Change of use of parts of seafront for temporary food & drink outlets & other seaside uses together with associated temporary/portable structures & equipment for use by businesses associated with those outlets.

Various sites along Littlehampton Promenade Littlehampton

Re. Planning Application LU/91/19/PL

SITE LOCATION PLAN AND
BLOCK PLAN - SITE C&D

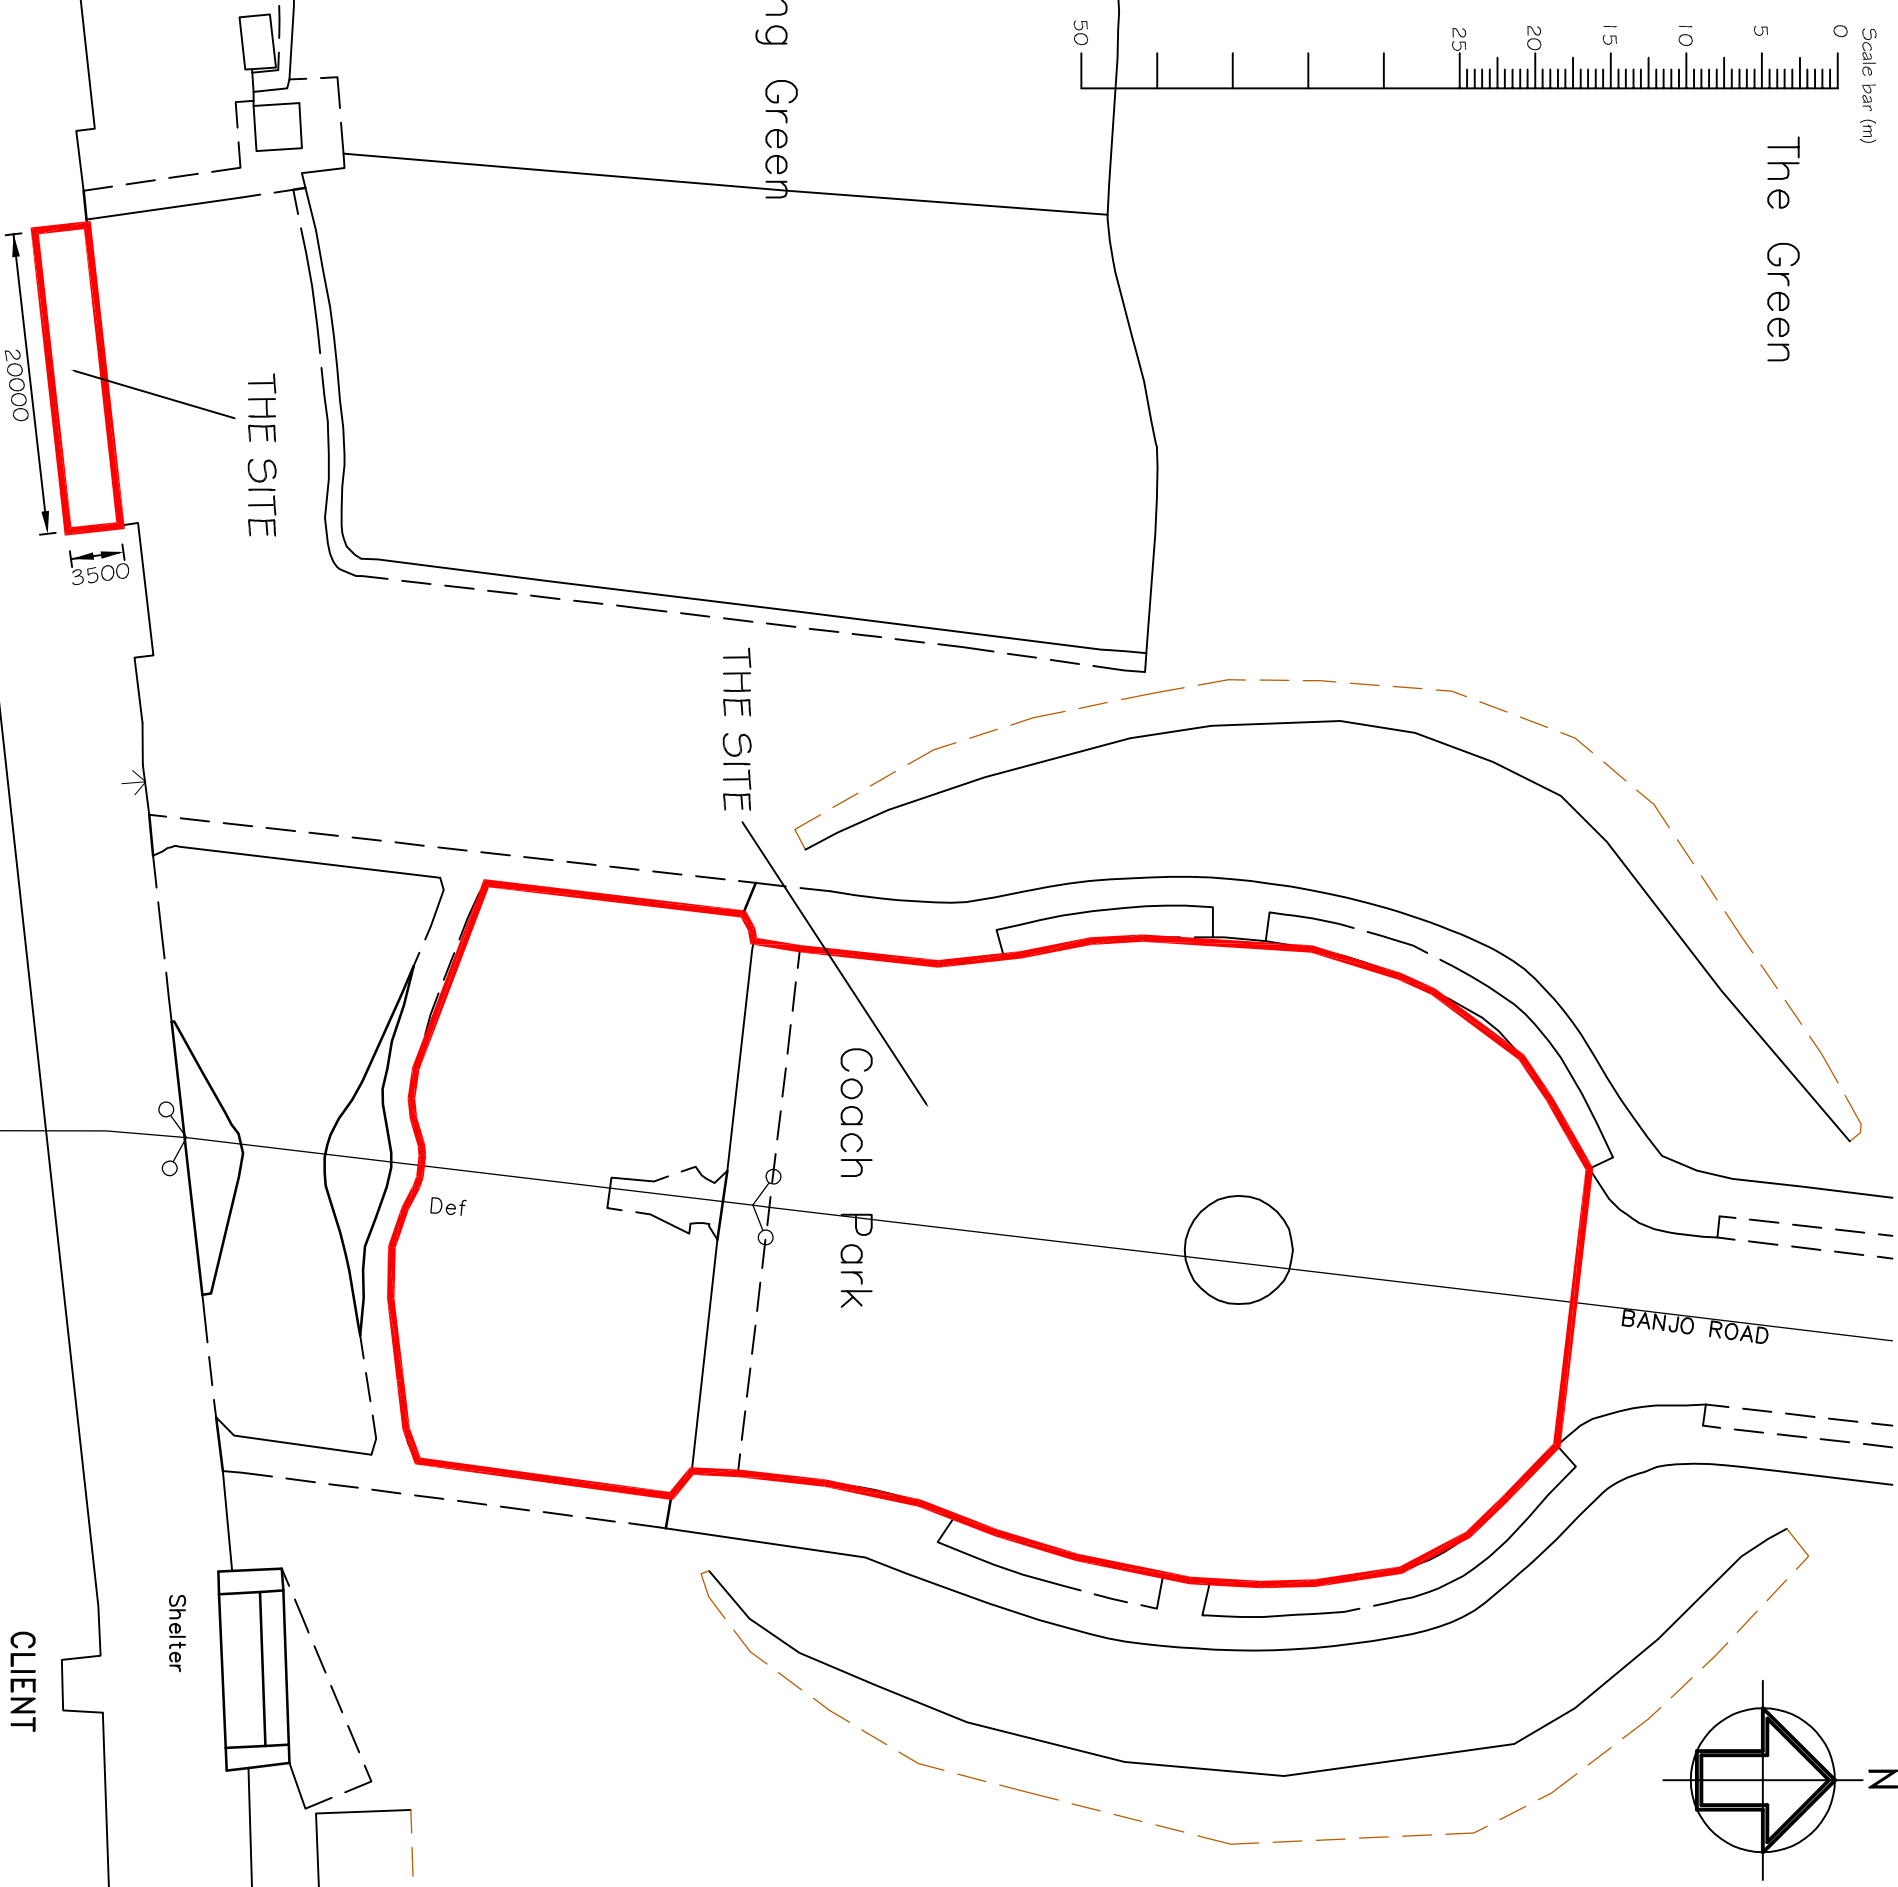
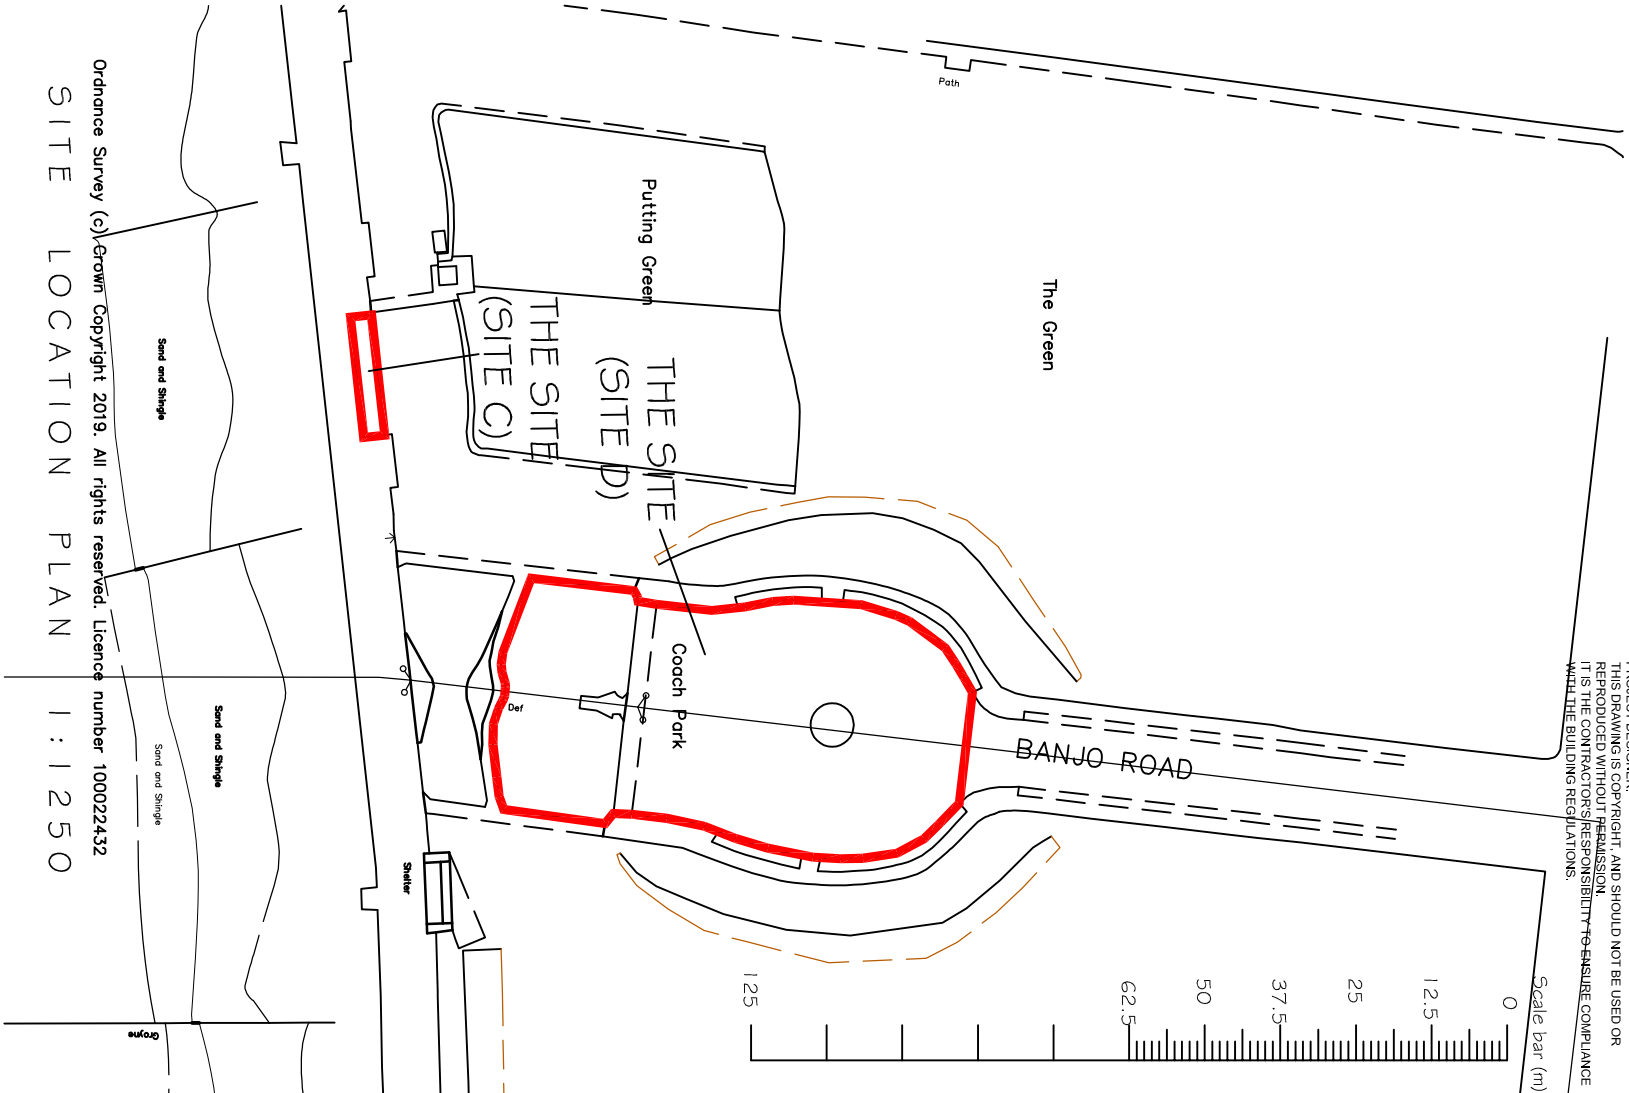
1. Loss of Critical Coach Park. The application results in the loss of the existing coach park at Banjo Road. Many of the seafront businesses rely on coach trade as do events held on the green area. There are no provisions to mitigate for this loss. Further to this, since there are no provisions, there will clearly be an impact on the surrounding roads in terms of parking and/or drop-off, this also has not been addressed.
